**LAND TO THE REAR OF MEADOW CROFT LING LANE, SCARCROFT, LEEDS**

**RETROSPECTIVE NON-MATERIAL AMENDMENT TO PLANNING APPLICATION REF. 20/04897/FU.**

Dwg. Title
 Proposed South Elevations
 Comparisons

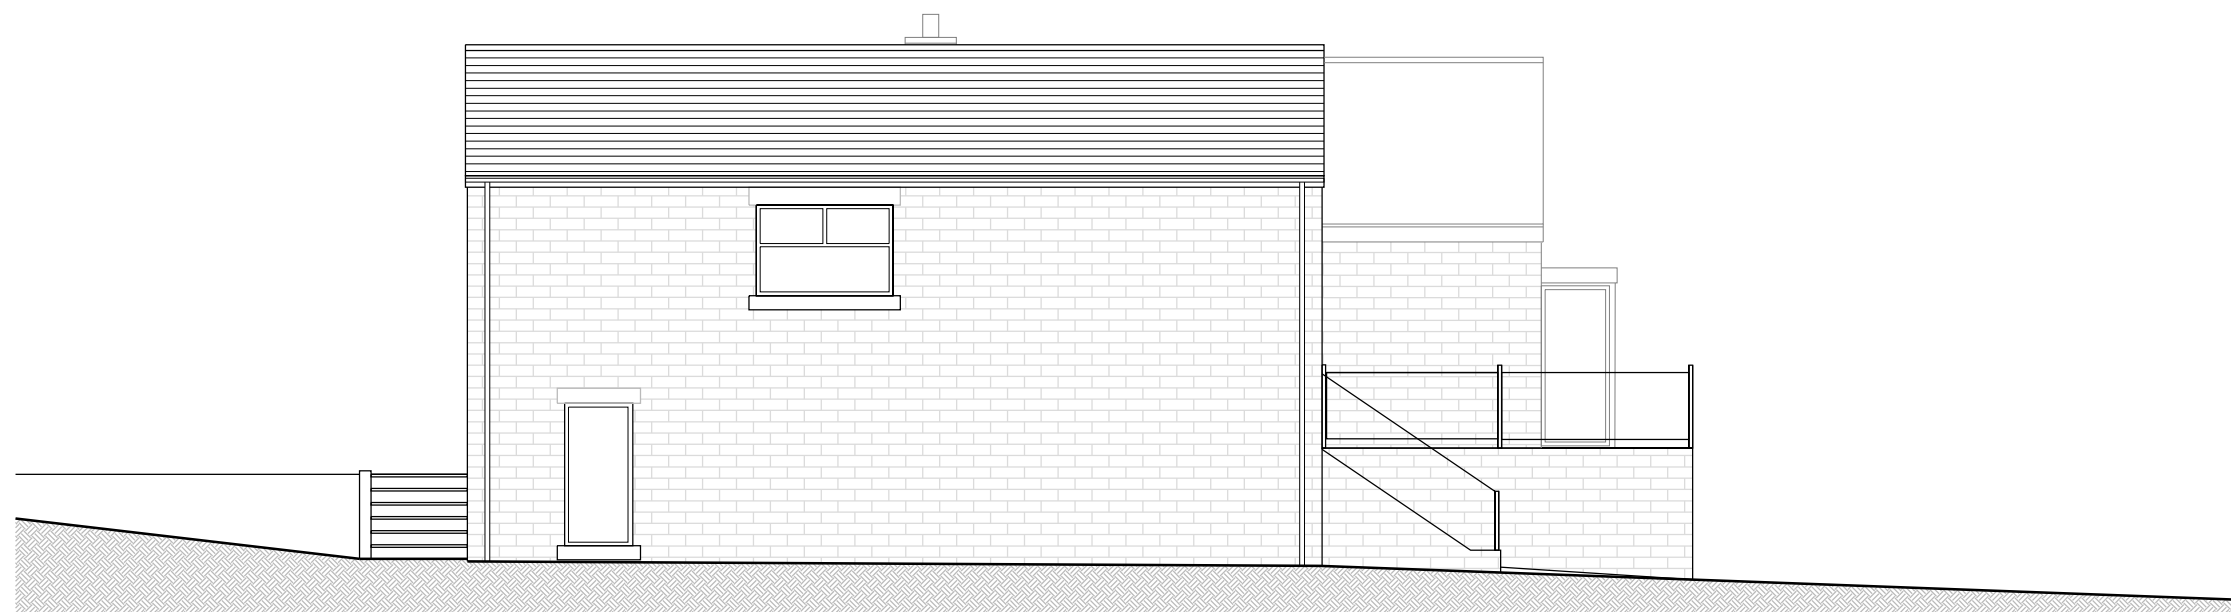
- Windows revised at first floor level with one omitted and glazing bars added to the other.
- Corner window omitted to remove solar gain issue on south-east corner.

Dwg. Title  
**Proposed West Elevations  
Comparison**

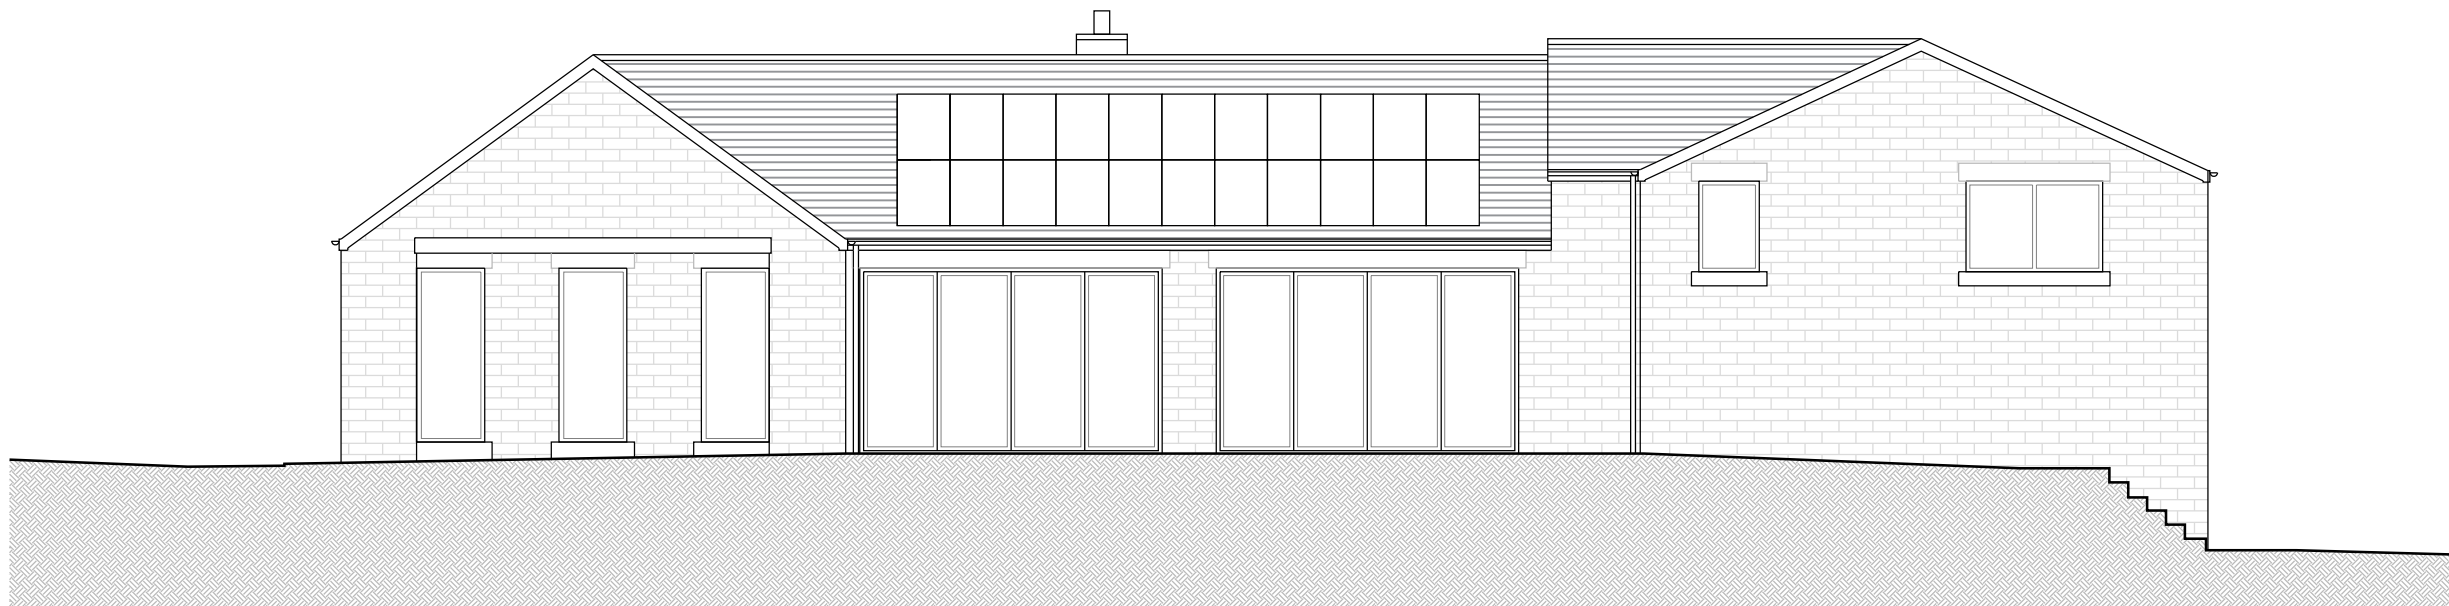
- Timber cladding omitted from bay.
- Photovoltaic array added to roof to improve the energy performance of the house.
- Chimney located on East Elevation.
- Window design to gable revised in relation to room layout inside.
